**Application for Planning Permission for Works or Extension to a Dwelling**

**Development:** Roof extension to facilitate conversion of loft to habitable use, including the installation of front and rear dormers.  
**Location:** Sunnymead North End Road Yapton BN18 0DL

PROPOSED WEST ELEVATION - [1:100]

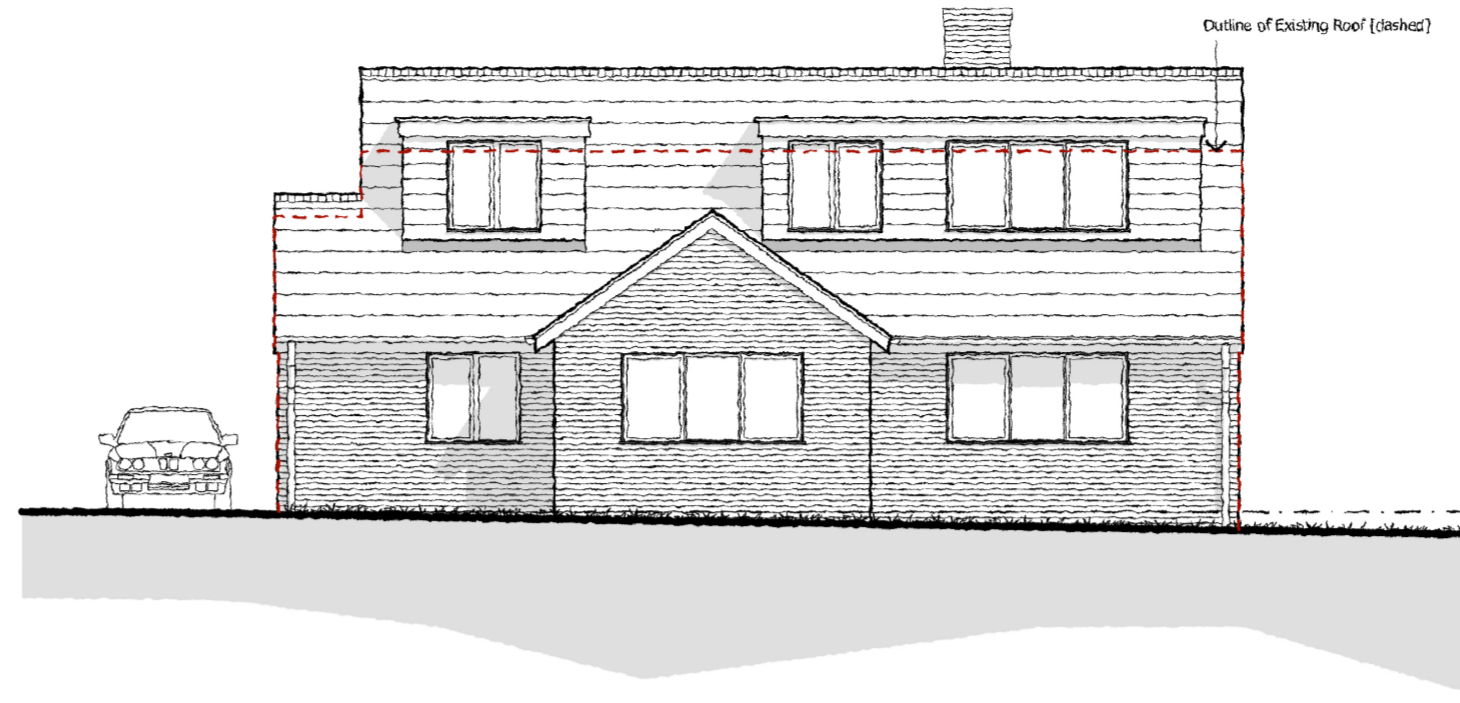
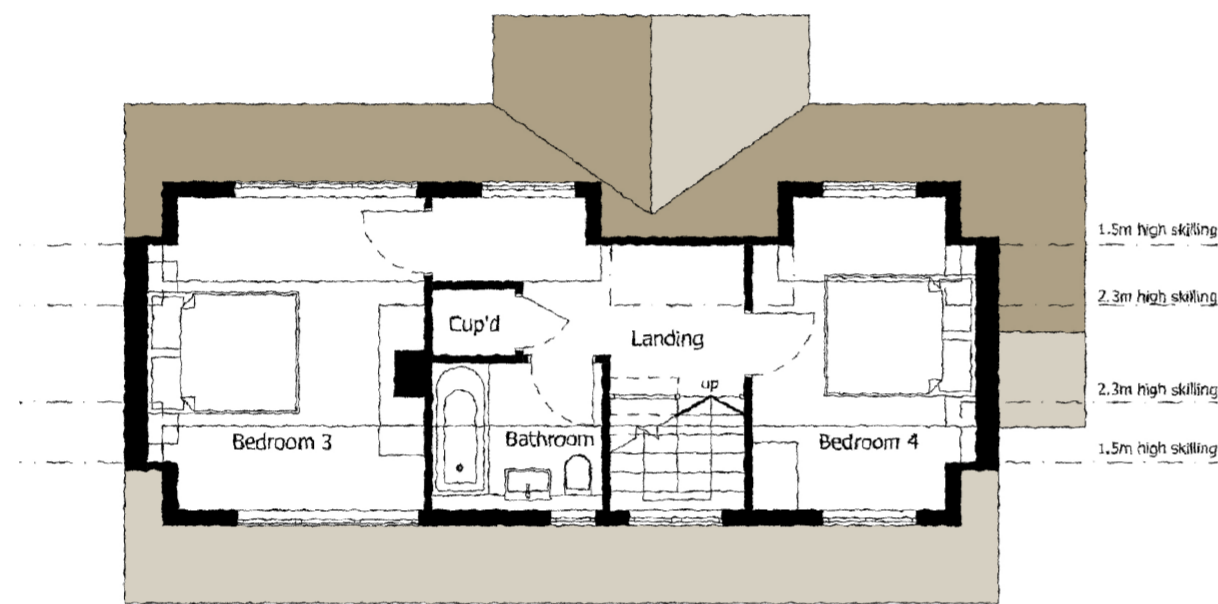
Inconsistent Plans

The bathroom window shown on the proposed west elevation is missing from the proposed first floor plan.
